WEST SUSSEX COUNTY COUNCIL CONSULTATION

TO:	Arun District Council FAO:M Tomalova
FROM:	WSCC - Highways Authority
DATE:	3 September 2019
LOCATION:	19 & 21 Nyewood Lane, Aldwick, PO21 2QB
SUBJECT:	AW/232/19/OUT Outline application with all matters reserved for demolition of 19 & 21 Nyewood Lane & erection of up to 20 No 1bed & 3 No 2bed flats.
RECOMMENDATION:	More Information
S106 CONTRIBUTION TOTAL:	to follow

CLIENT		PROJECT		TITLE		STATUS		DRAWN BY		REVIEWED BY	
P. BRESKAL & K. RICHARDS		19 – 21 NYEWOOD LANE, BOGNOR REGIS		ILLUSTRATIVE STREETSCENE		PLANNING		S.J.		S.J.	
						DATE		SCALE		DRAWING NUMBER	
						09.08.2019		1:100 @ A2		6

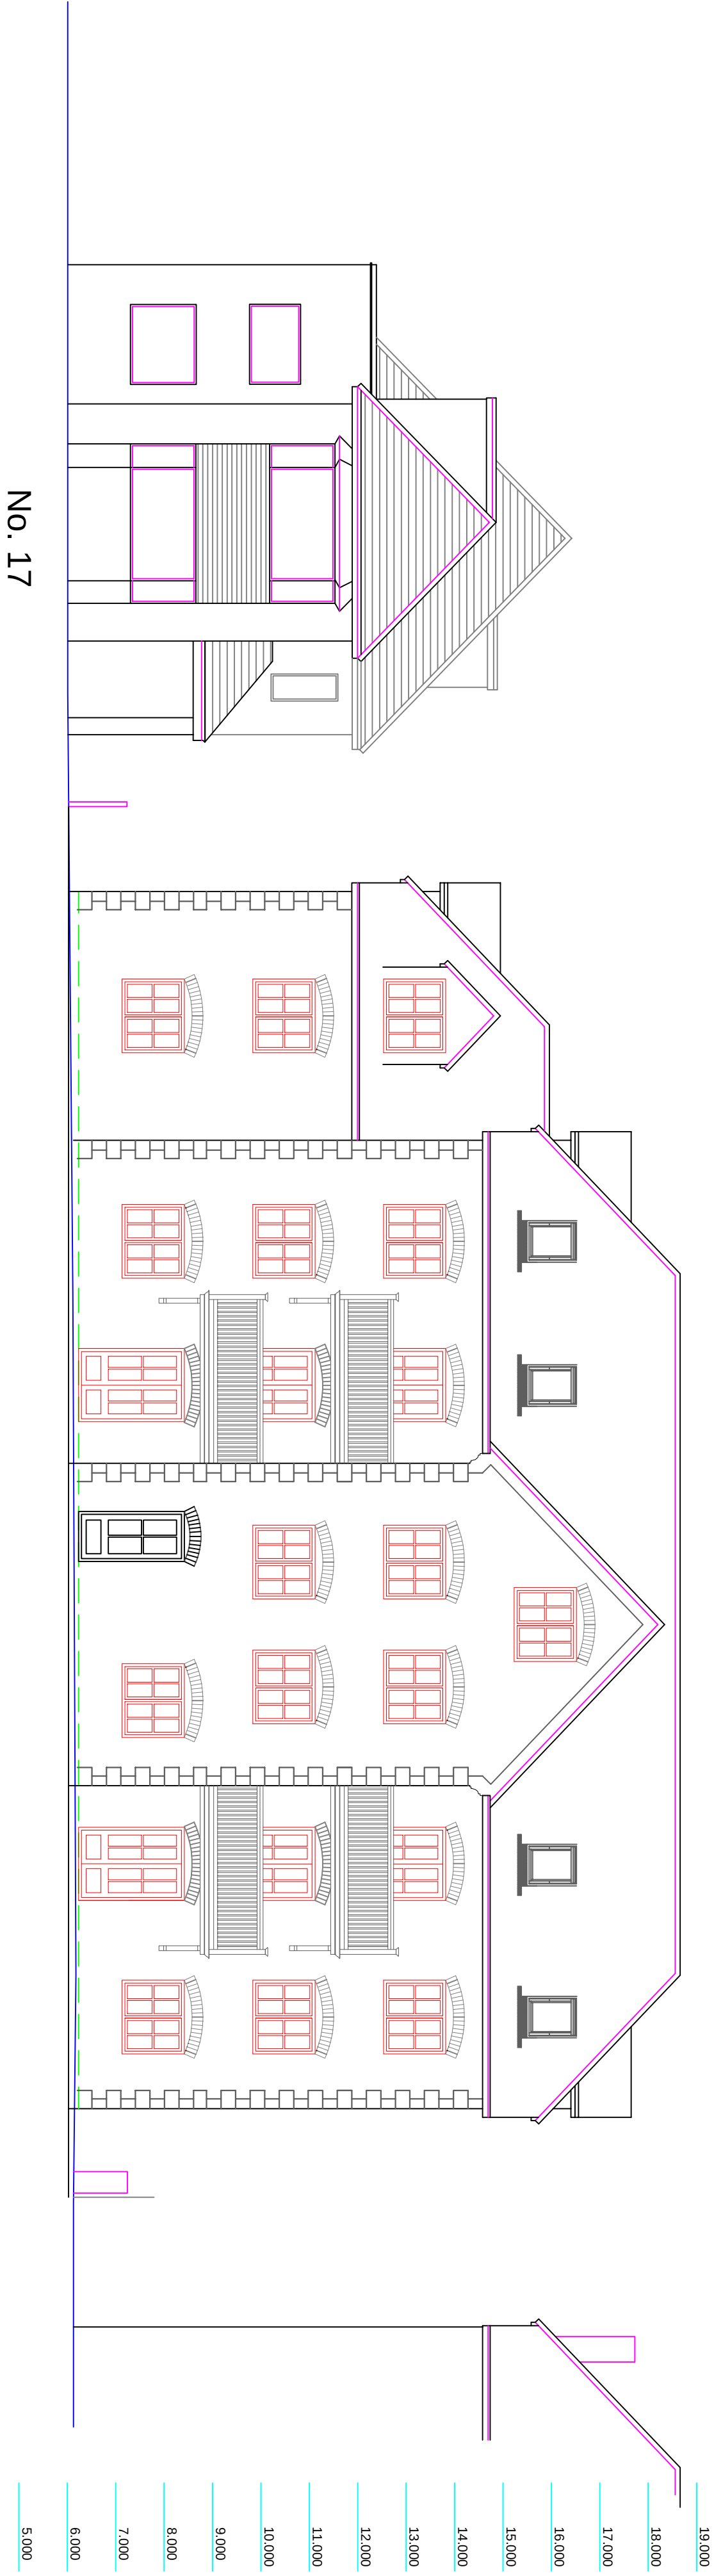
Whilst no extensions to existing dropped kerb are proposed, it does appear that this may be required to provide access to all 10 x off-street parking spaces. Furthermore, it is unclear whether access to northern and southern most spaces would require passing through on-street parking bays and thus through a Car Parking Zone (CPZ). If so then an alteration to the existing Traffic Regulation Order (TRO) may be required. Plans should clearly indicate extent of dropped kerb required and whether proposed parking spaces are adjacent to on-street parking bays.

The site plan indicates 10 x parking spaces off the road (on frontage of site). One space will be provided with electric vehicle charging point. The Planning Statement outlines

that 1 space per 2 flats will therefore be available. The applicant should clarify whether any spaces will be allocated or will be provided on a first come first serve basis.

In summary, whilst the principle of the application is considered to meet with paragraph 109 of the National Planning Policy Framework, in that a 'severe' cumulative impact on the operation of the highway network is not expected, the matters relating to access to car parking spaces as outlined above should be addressed and clarified on a detailed to scale plan. If access is required through on-street parking bays then dropped kerb may require extending and the Parking Team may need to be consulted regard any impact/ altering of parking zone.

Please ask the applicant for this additional information and re-consult.
